## WEST SUSSEX COUNTY COUNCIL CONSULTATION

| <b>LOCATION:</b>                | Land off, Burndell Road, Yapton, Arundel                                                                                                                                                                                                              |
| <b>SUBJECT:</b>                 | Y/102/18/DOC<br>Approval of details reserved by condition imposed under ref APP/C3810/V/16/3158261 relating to Condition No 13 Construction Management Plan.                                                                                          |

DRAWING TITLE:
 BUILD SEQUENCE DRAFT

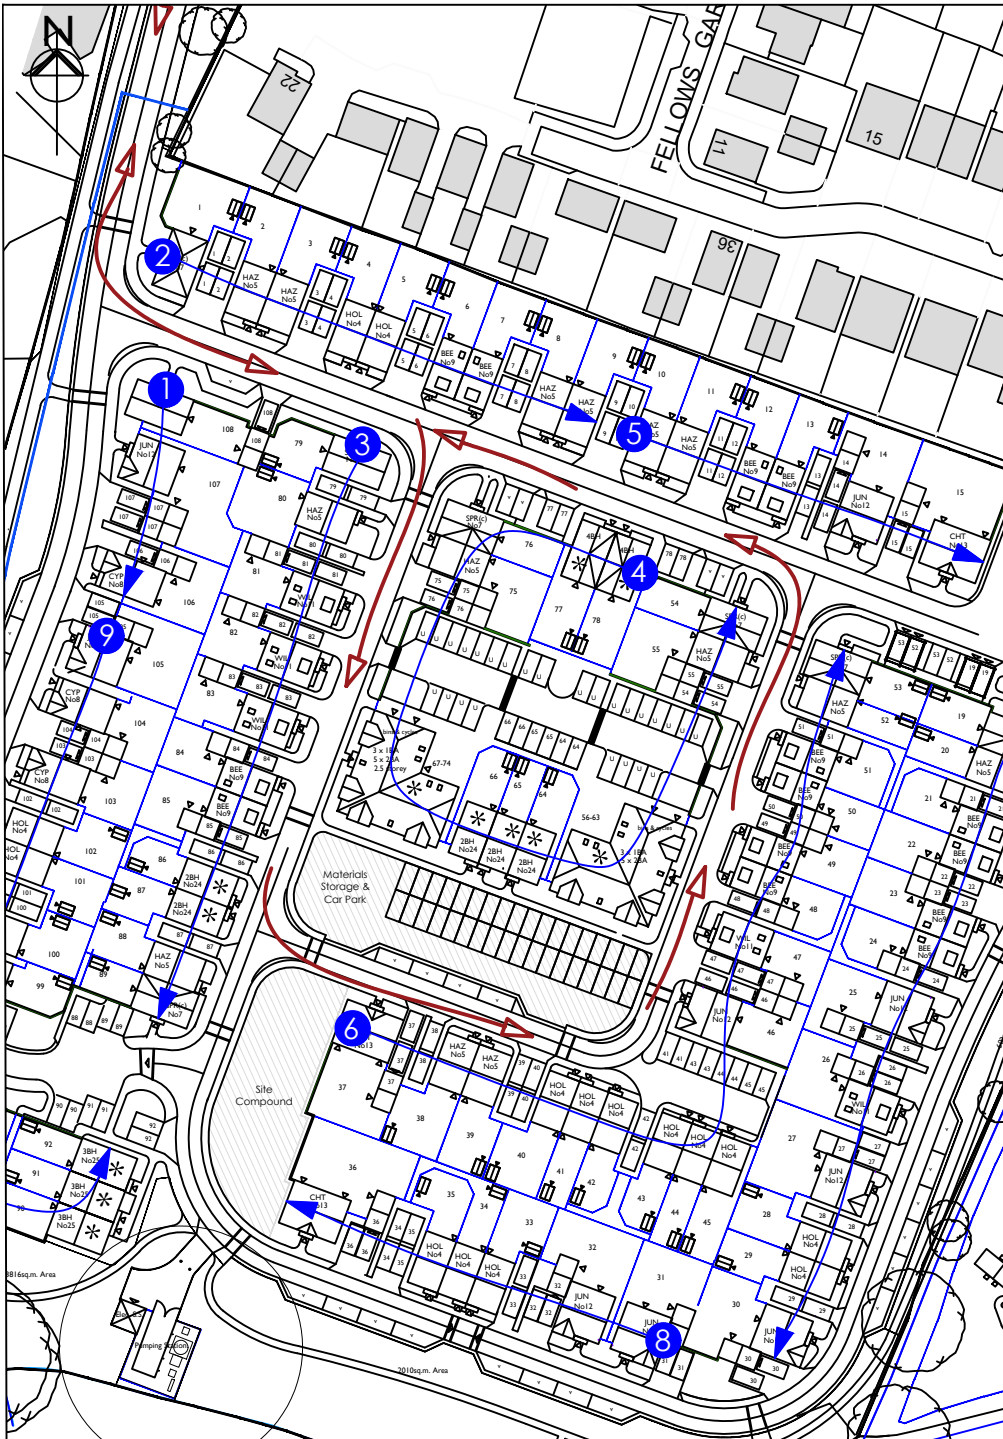
- Section 2 "Method access and routing etc."** - Condition 20 of the planning consent requires the access and associated works onto Burndell Road to be completed prior to works commencing on-site. Therefore, anything approved under condition 13 should not override this requirement. Also, an off-site road routing plan should be submitted. Finally, a detailed plan showing the location of the site hoarding adjacent to the access (and how this impacts on access and visibility splays) should be shown on a detailed plan. *Hoarding needs to be set-back 20m from kerb-line on Burndell Road to accommodate large vehicles and to ensure that they don't overhang the highway. Please confirm and show that this will be the case. The routing should be the same as that for the neighbouring site permitted under planning reference F/16/18/DOC. As such, a revised plan should be provided showing this. Finally, WSCC Public Rights of Way (PRoW) Team should be consulted for their specific requirements for the adjacent Public Footpath throughout the course of construction on the site. PRoW contact details are as follows:*

SITE COMPOUND

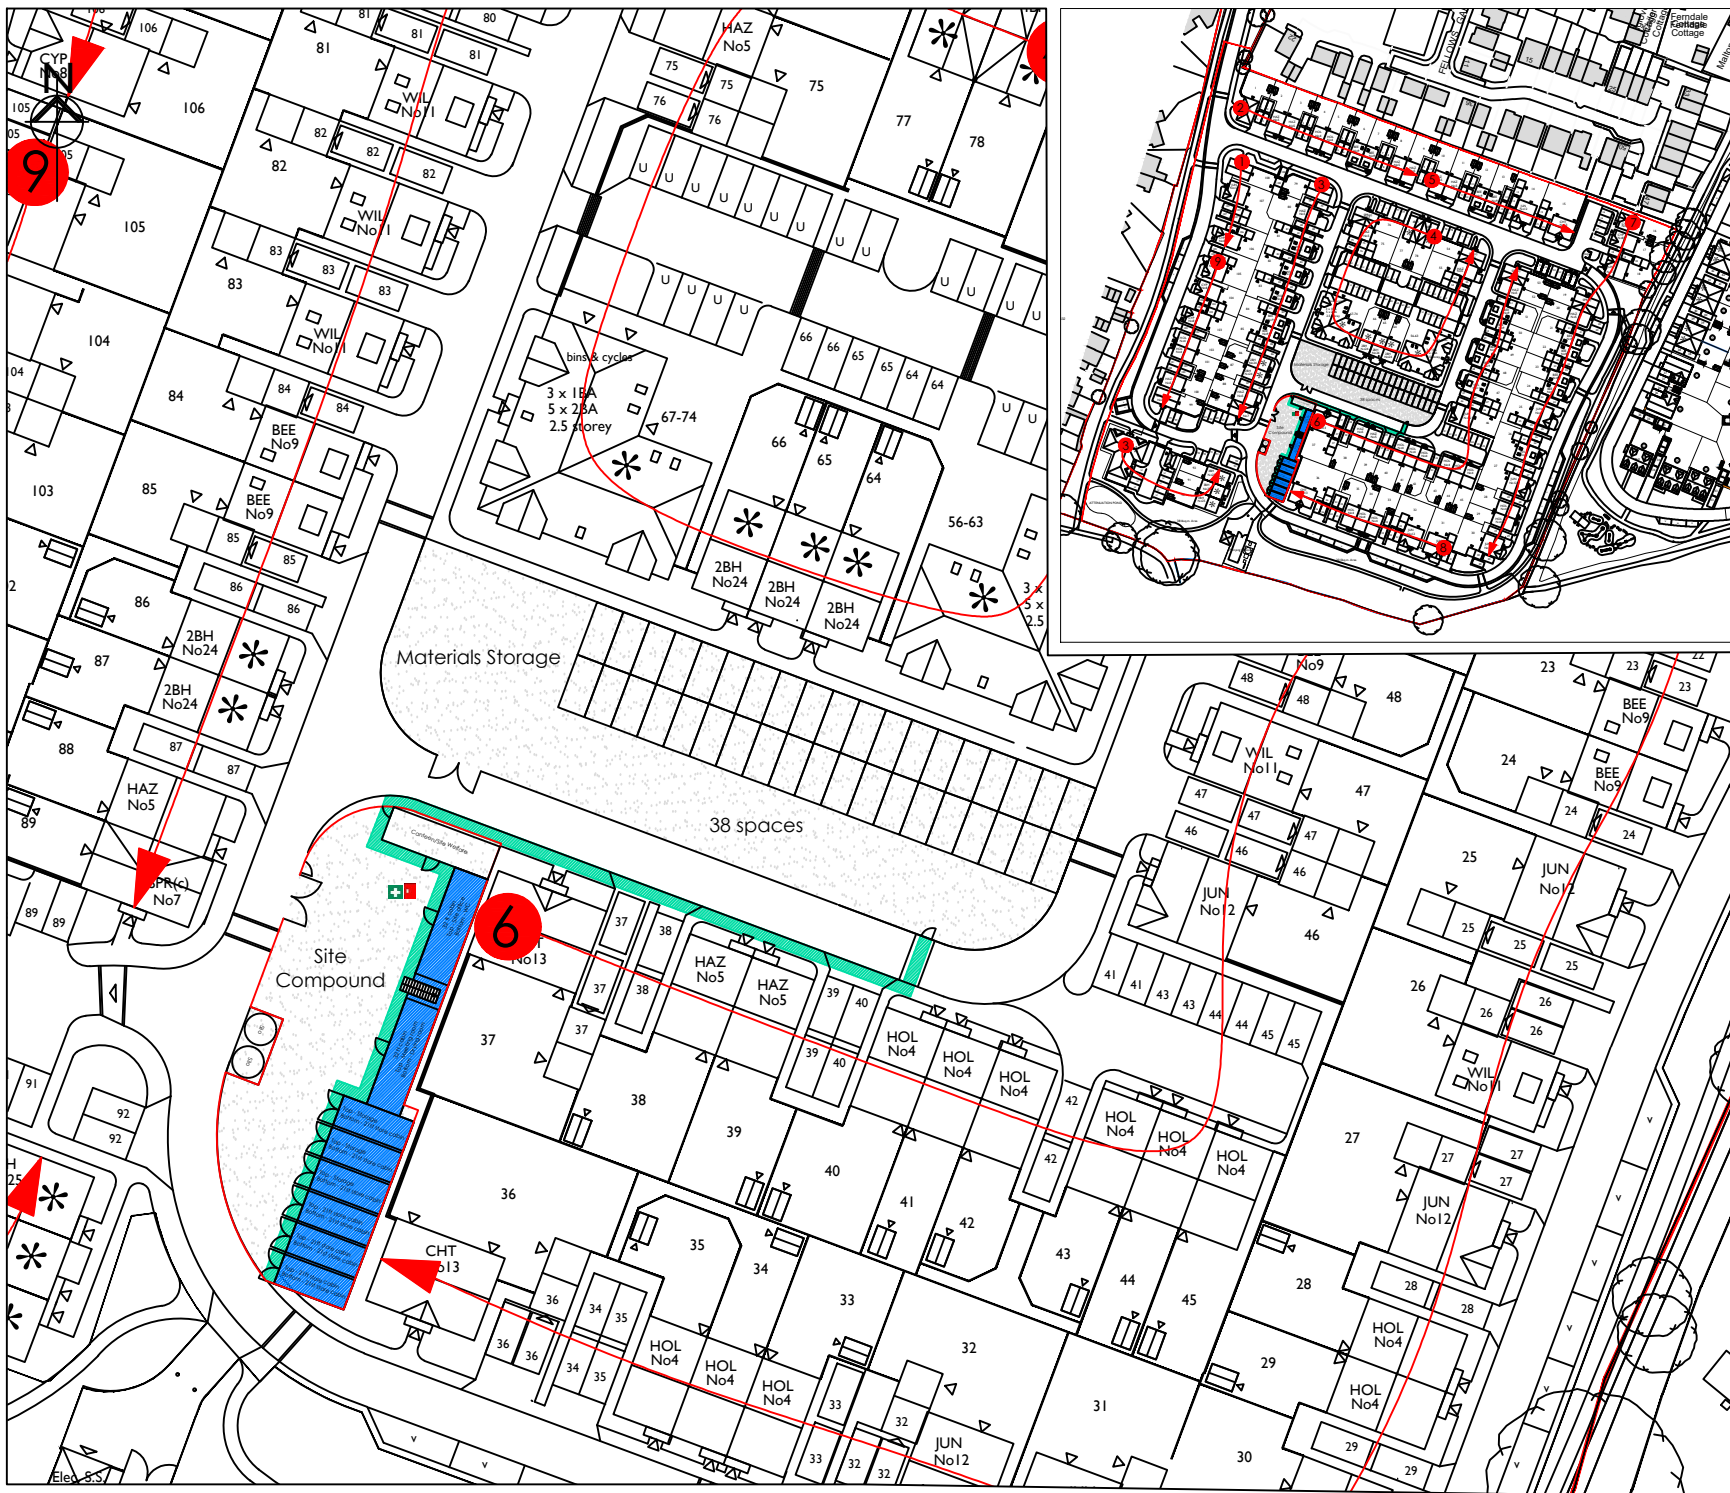
[REDACTED]
- Section 3 "The parking of vehicles etc."** – As well as no delivery vehicles being permitted to park or lay-up on adjacent roads, the CMP should also state that no operatives or visitors should do this either and all be accommodated within the site. The applicant should also confirm that all vehicles will be provided with adequate on-site turning and that they will only enter and leave the highway in a forward gear. *Comments noted. No further reply needed.*
